March 16, 2023

Re: Precision Eye Center 7521 Alameda Blvd. NE Traffic Circulation Layout Engineer's Stamp 02-13-23 (C19-D070)

Based upon the information provided in your submittal received 03-16-23, the above referenced plan cannot be approved for Building Permit until the following comments are addressed:

TRAFFIC
CIRCULATION
LAYOUT

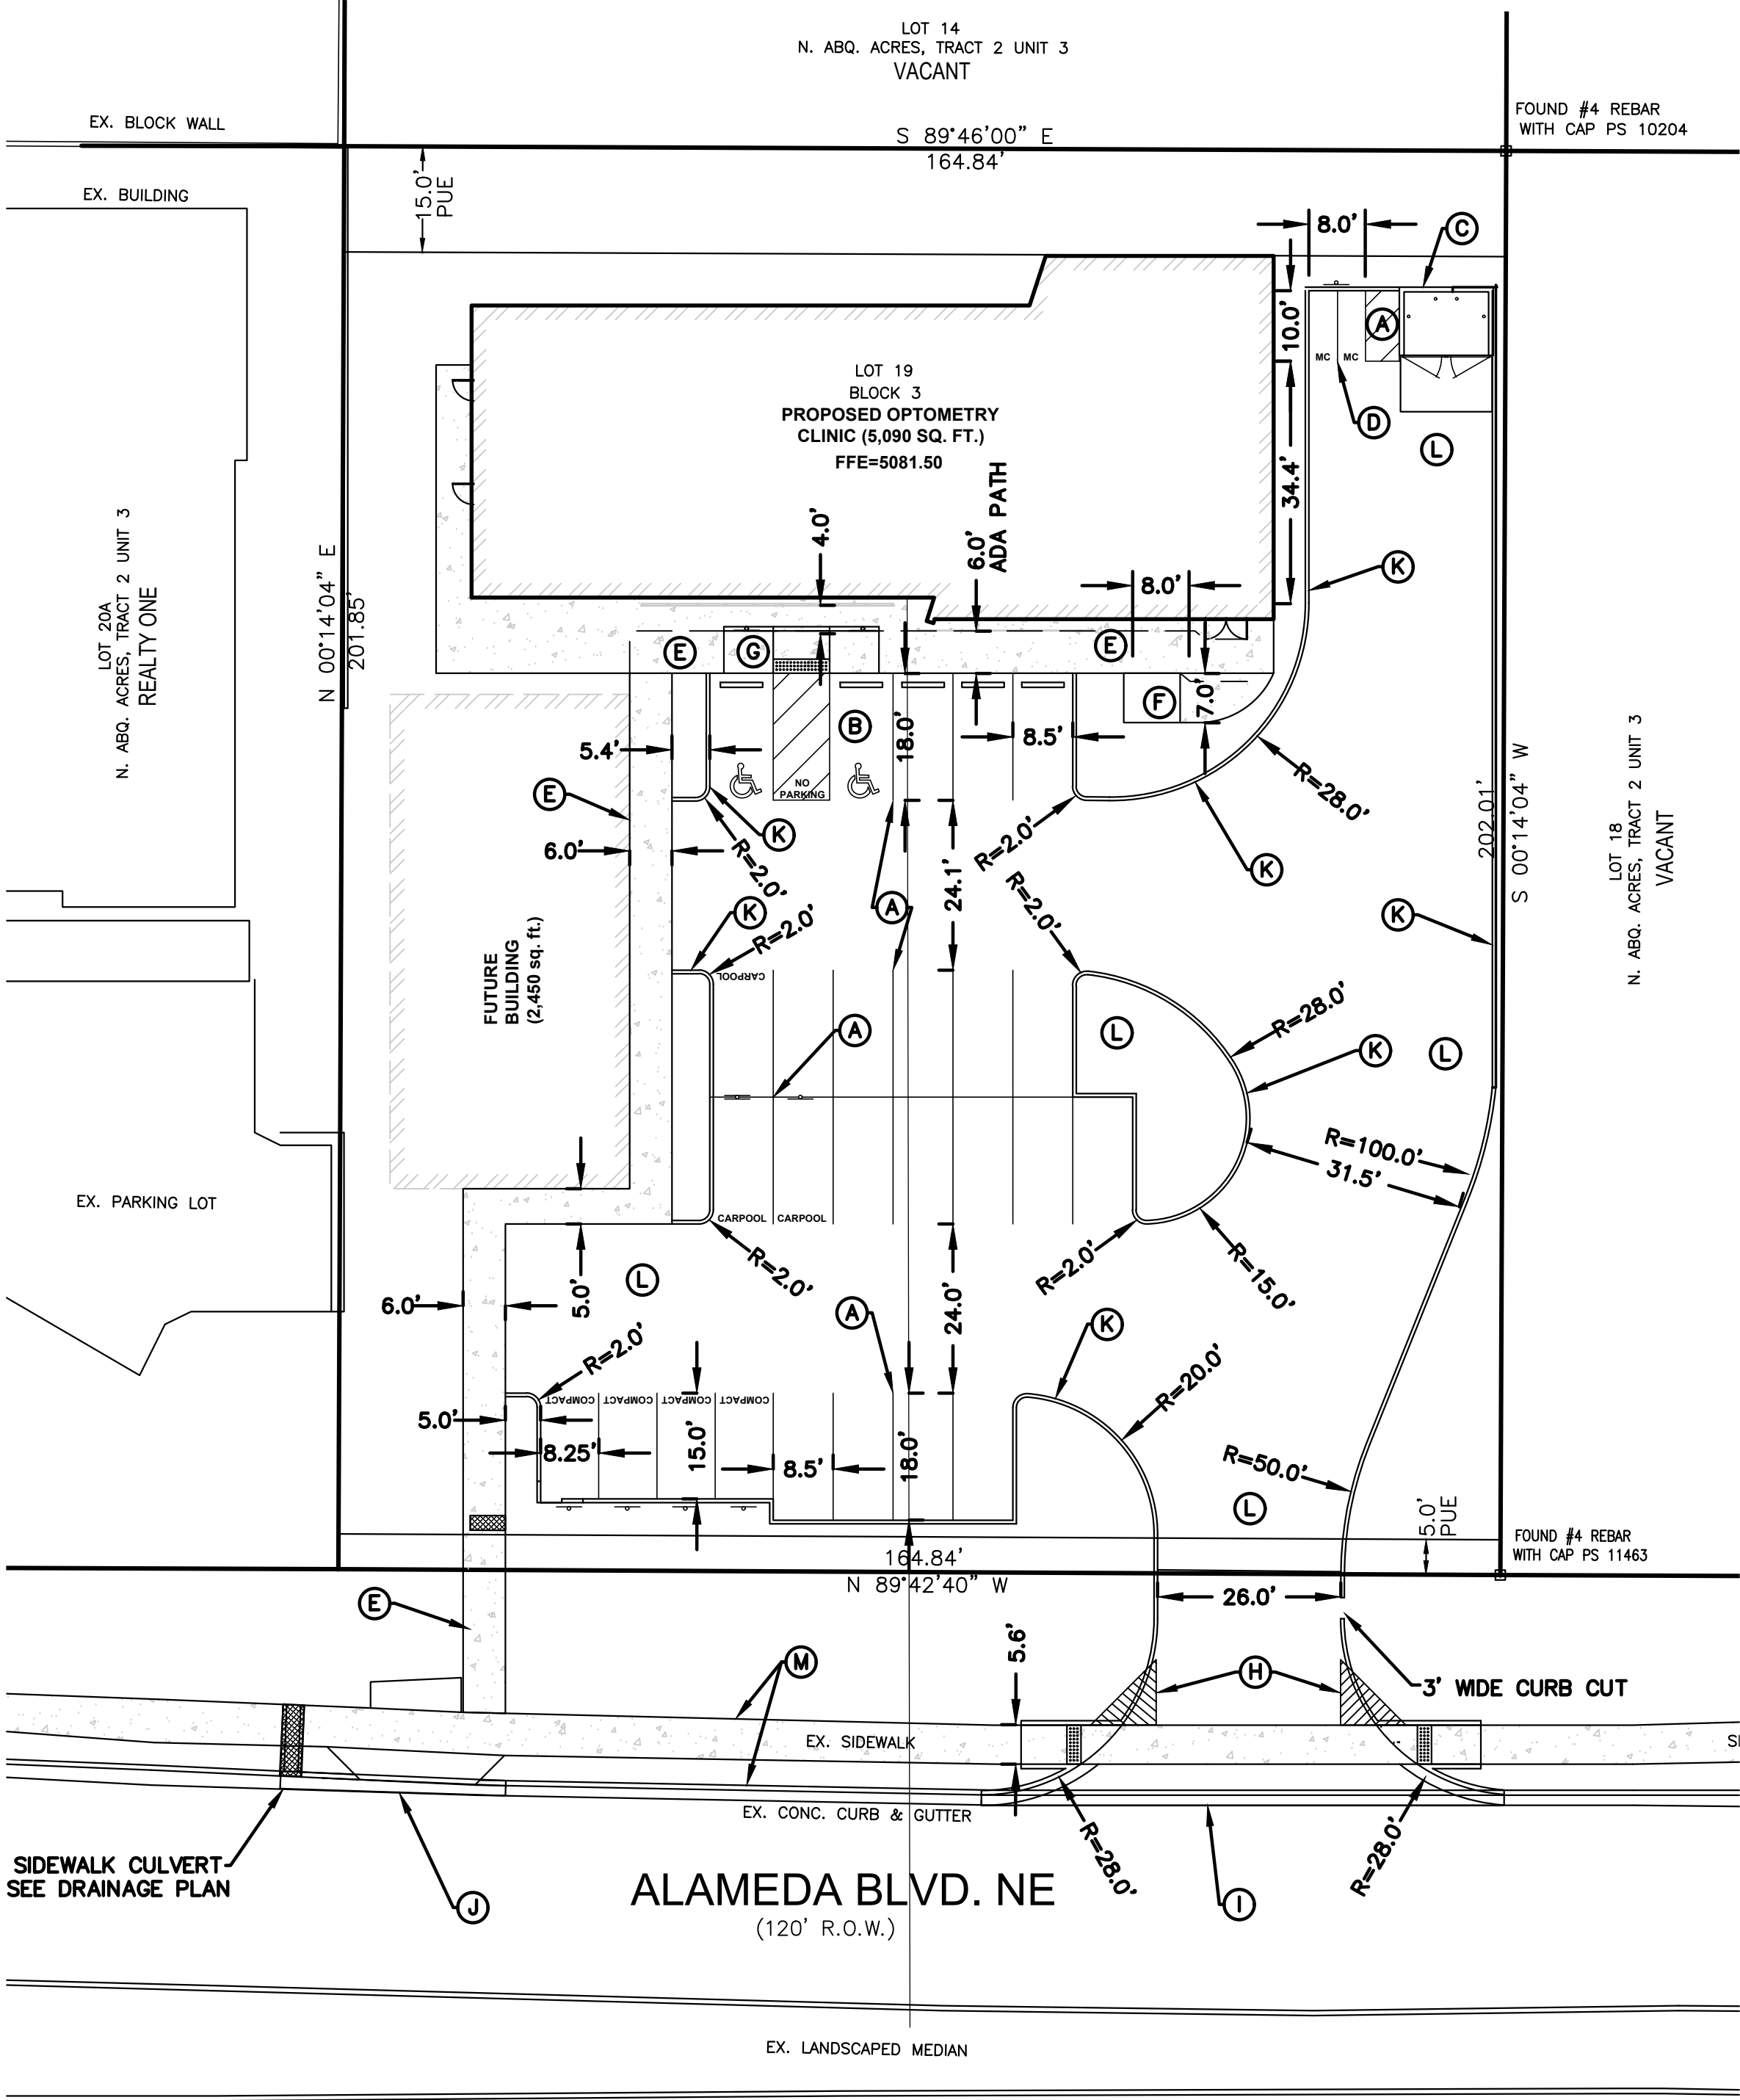
Per City standard Compact parking space should be minimum 15 ft. in length.

The ADA access aisles shall have the words "**NO PARKING**" in capital letters, each of which shall be at least one foot high and at least two inches wide, placed at the rear of the parking space so as to be close to where an adjacent vehicle's rear tire would be

1. Identify all existing access easements and rights of way width dimensions.

- 4. A 5 ft. keyway is required for dead-end parking aisles.
- 5. Please remove Plumbing details from Transportation details' sheet D-101.
 - 6. Refuse vehicle maneuvering shall be contained on-site. The refuse vehicle shall not back into the public right of way.; provide a copy of refuse approval.
